21 December 2020

**RIDBC Centre of Excellence (SSD-10451)
Response to Submissions**

ATTACHMENT 1

1 SECTION
ZONE 2 - EAST/WEST
SCALE 1:200

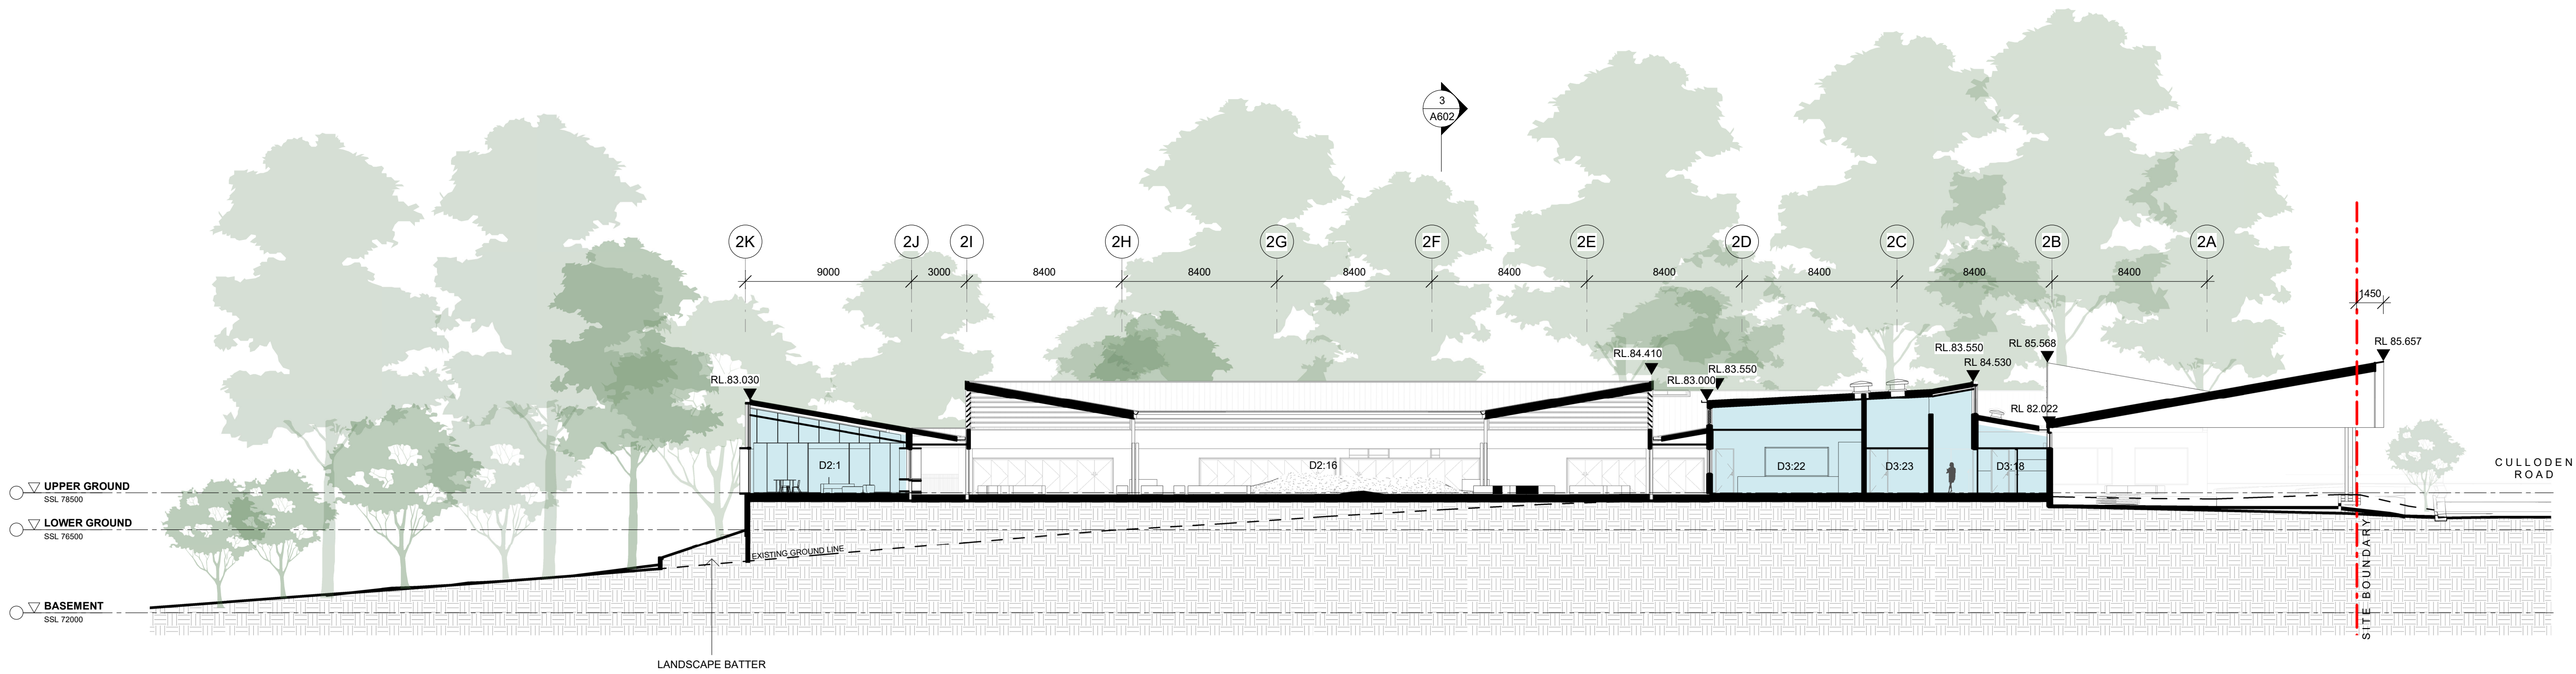
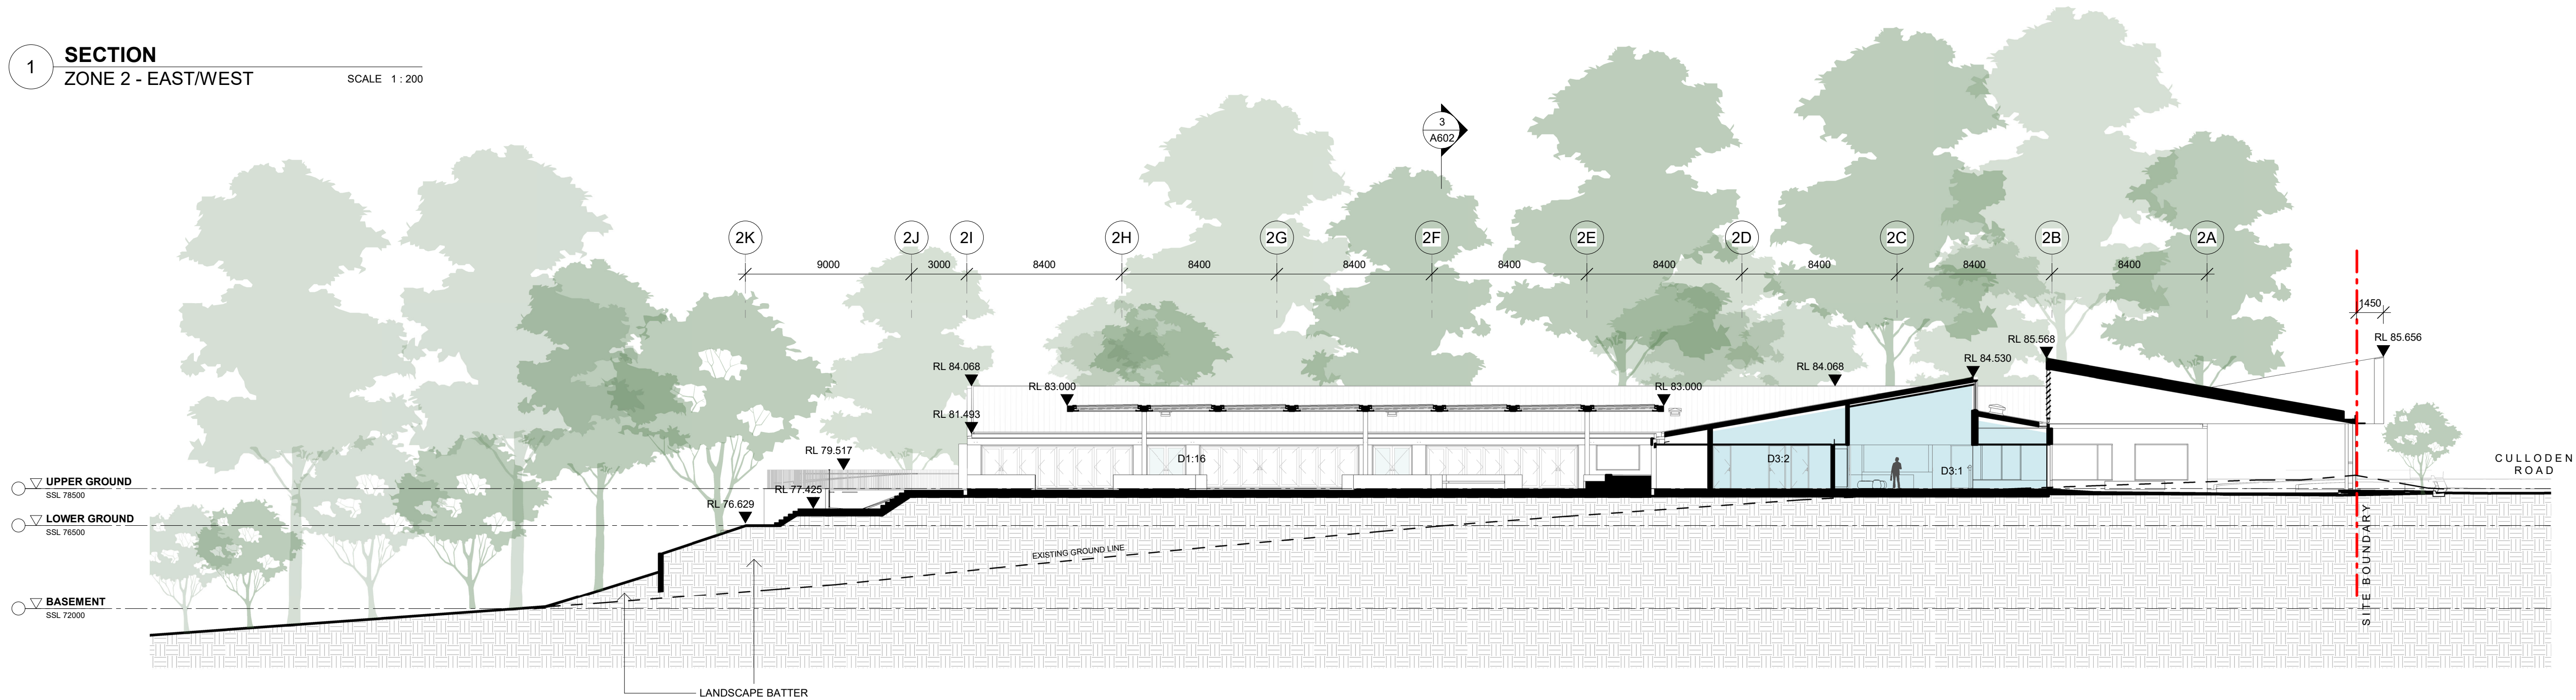
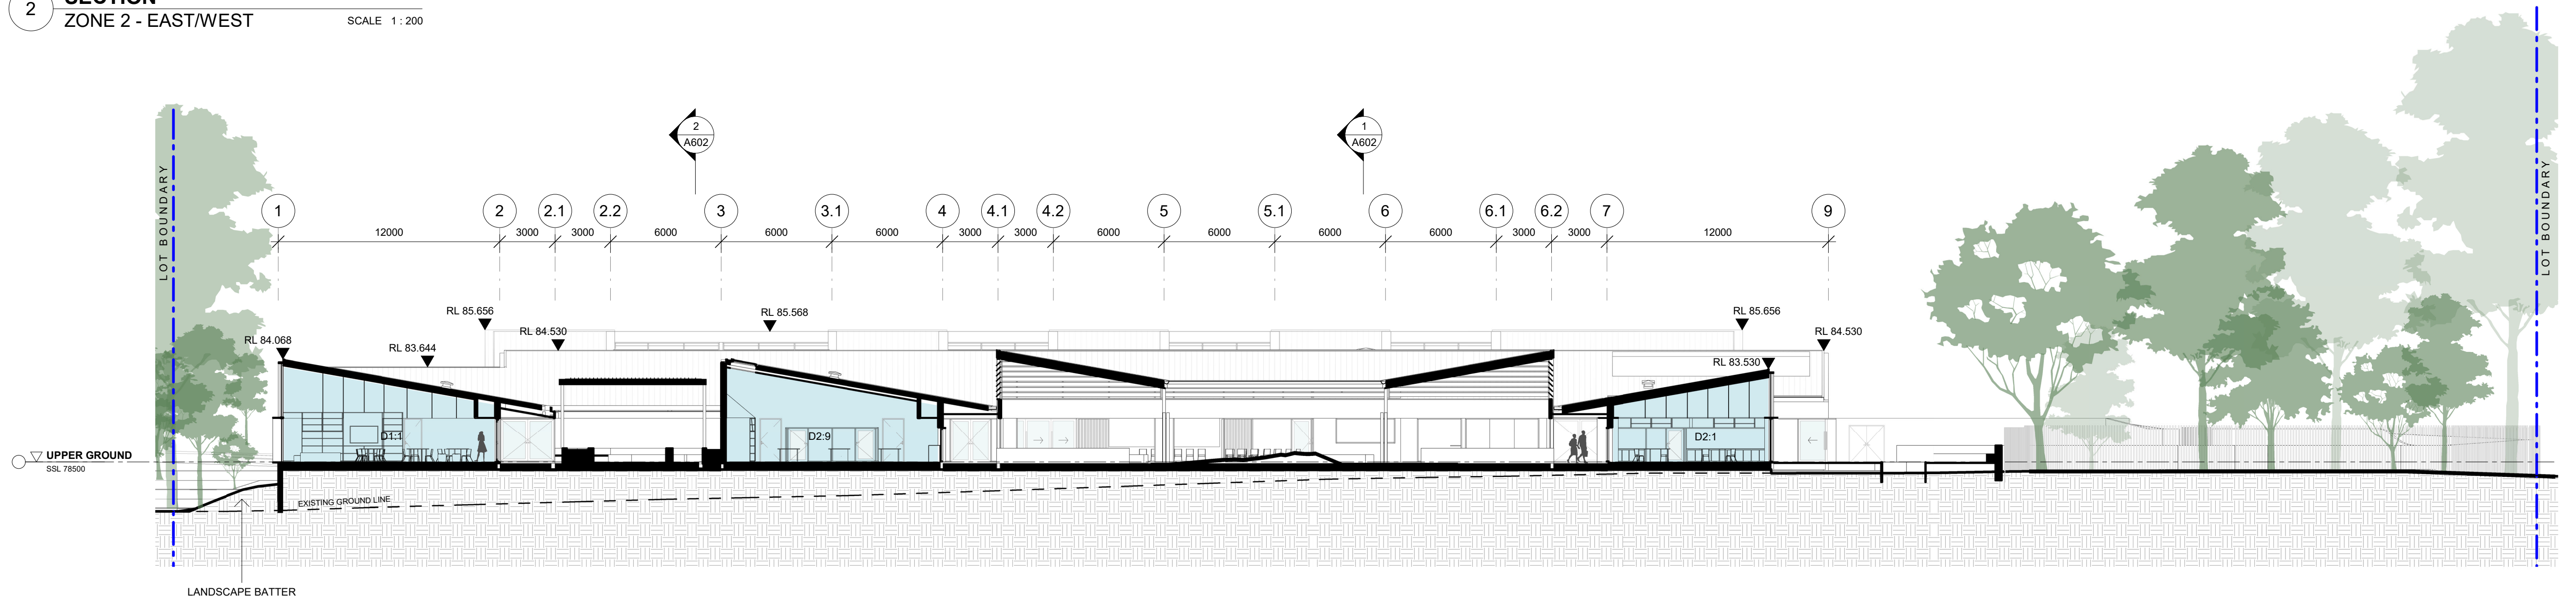
- The Department requires you to submit amended architectural plans including:
 - appropriate height information on all elevations and sections to ensure an appropriate assessment of the proposed maximum building height. The building height (in meters) should be provided considering the greatest vertical distance between existing ground level and the highest point of the buildings. The relative levels (RLs) of the topmost parts of the building should also be included.

- a line indicating existing ground level on all elevations and sections.
 - information on the height of the basement entrance level on elevations and sections to demonstrate the clearance height and that it can accommodate a medium rigid vehicle (MRV). The Department notes the Transport Impact Assessment outlines a “clearance height of up to 4 metres (m)” is provided, however this cannot be verified by the information available in the submitted plans.

Culloden Road Frontage - Plan

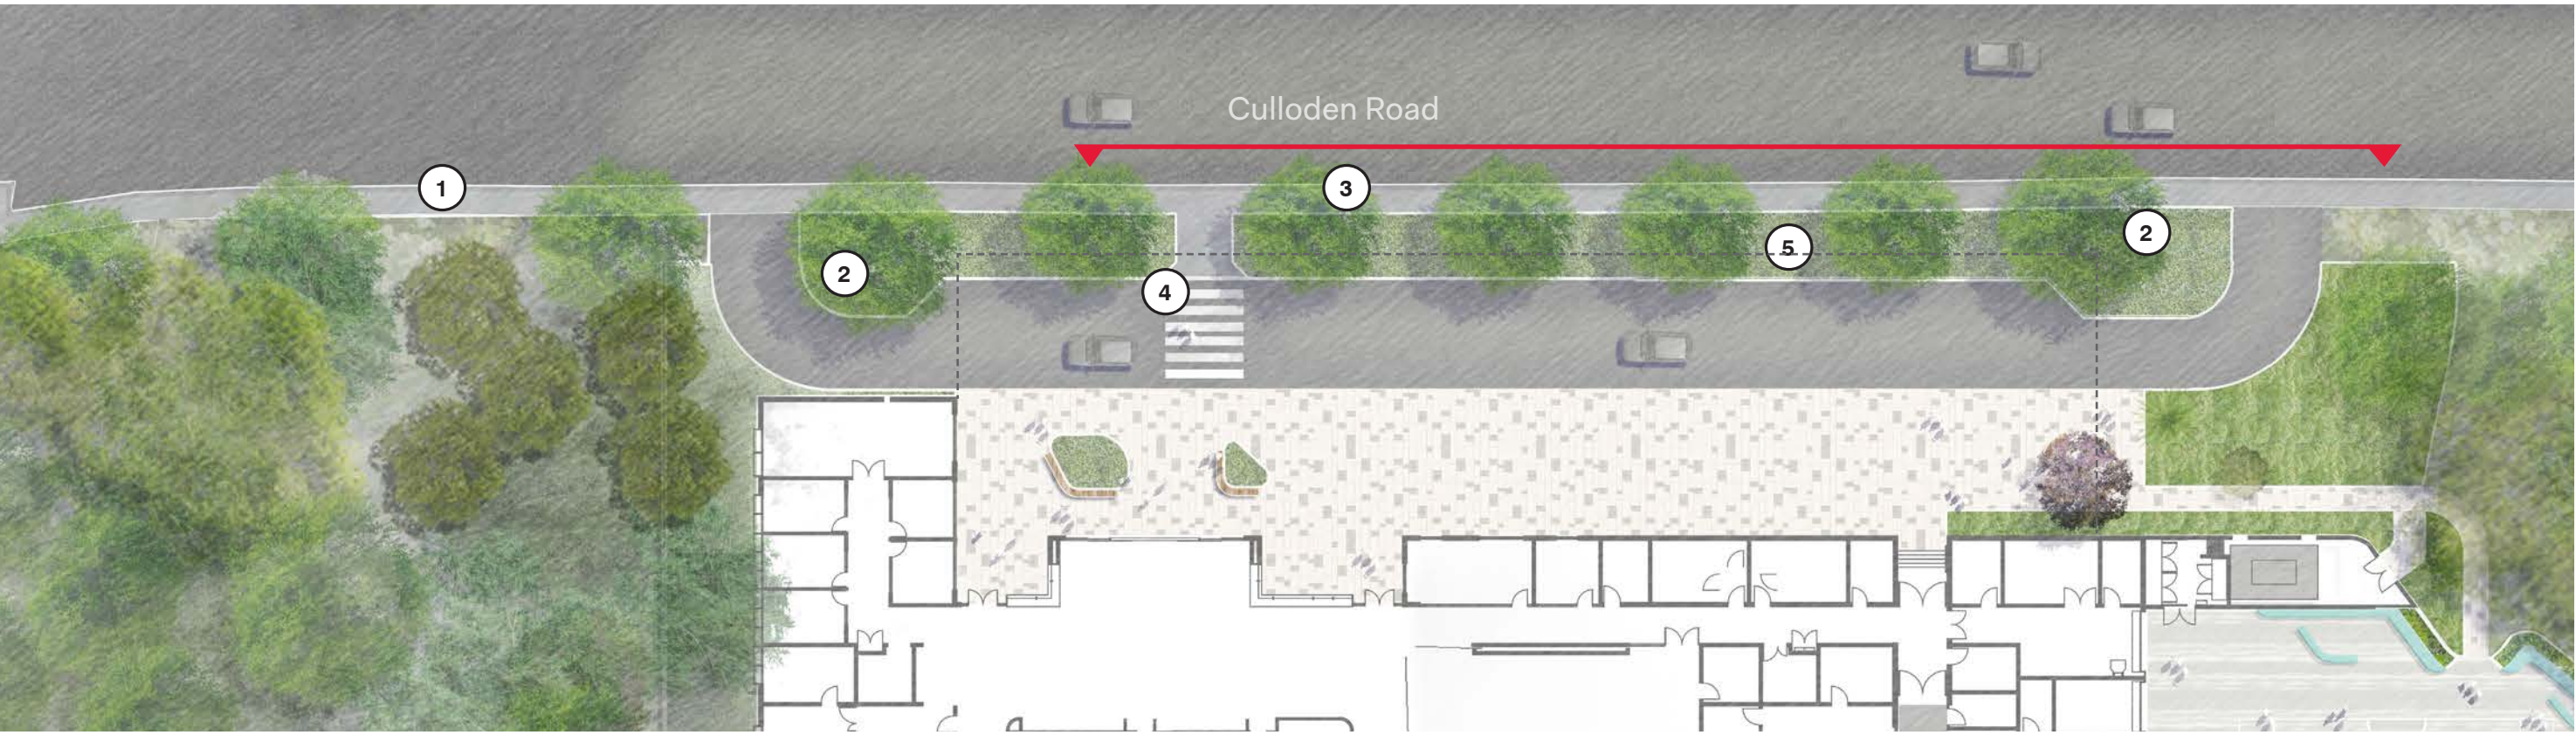
- The Department notes that Council has raised significant concerns regarding the environmental and visual impacts of the proposed tree removal, with particular concern regarding lack of a tree canopy along the Culloden Road frontage. The Department agrees with these concerns and requires you to investigate opportunities for further tree retention within the site.
- The proposed landscape strategy includes trees planted over underground structures. For example, the courtyard in the consulting building includes a feature tree (*Acer palmatum* 'Senkaki' 'Coral Bark Maple', mature size 6m x 5m) above the on-site

Pre-School Courtyard - Plan

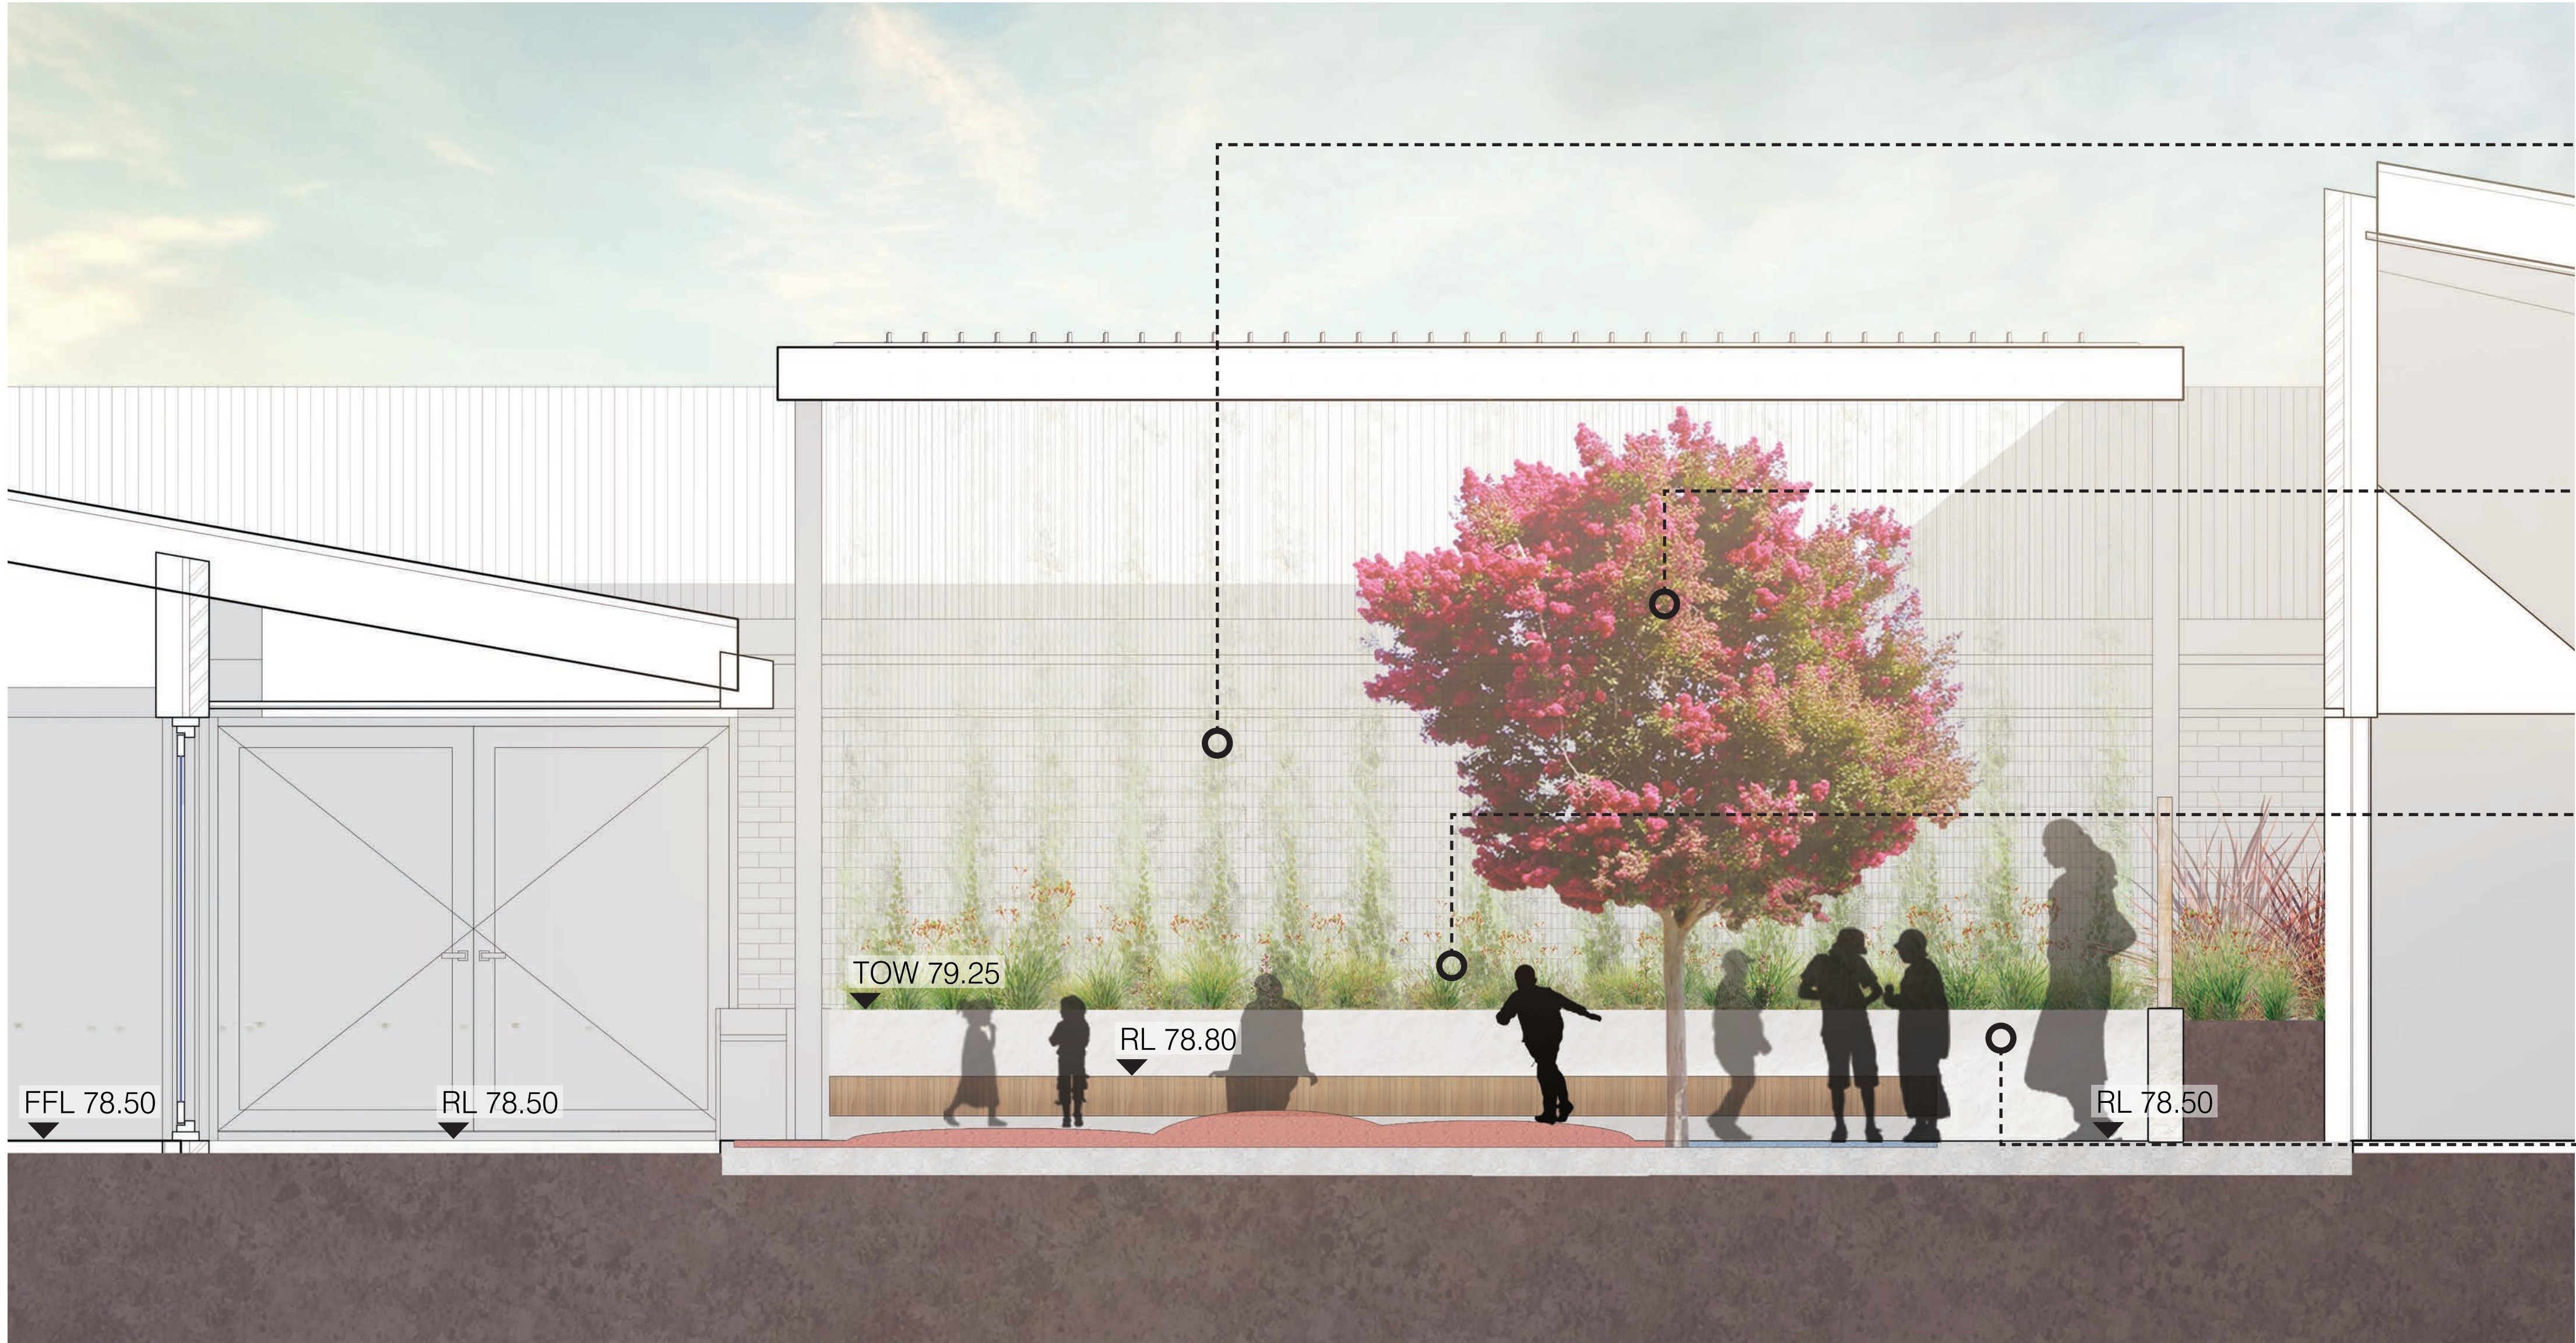
- The Department notes that the EIS includes an assessment against State Environmental Planning Policy (Educational Establishments and Child Care Facilities) 2017 and the Child Care Planning Guideline 2017. In this assessment, it is outlined that compliance is achieved with regards to unencumbered indoor and outdoor play space. However, there are no figures or plans verifying the unencumbered play areas.
- Consequently, the Department requires you to provide an addendum to the EIS that shows the entire floor plan for the pre-school, with the unencumbered spaces hatched to demonstrate compliance.
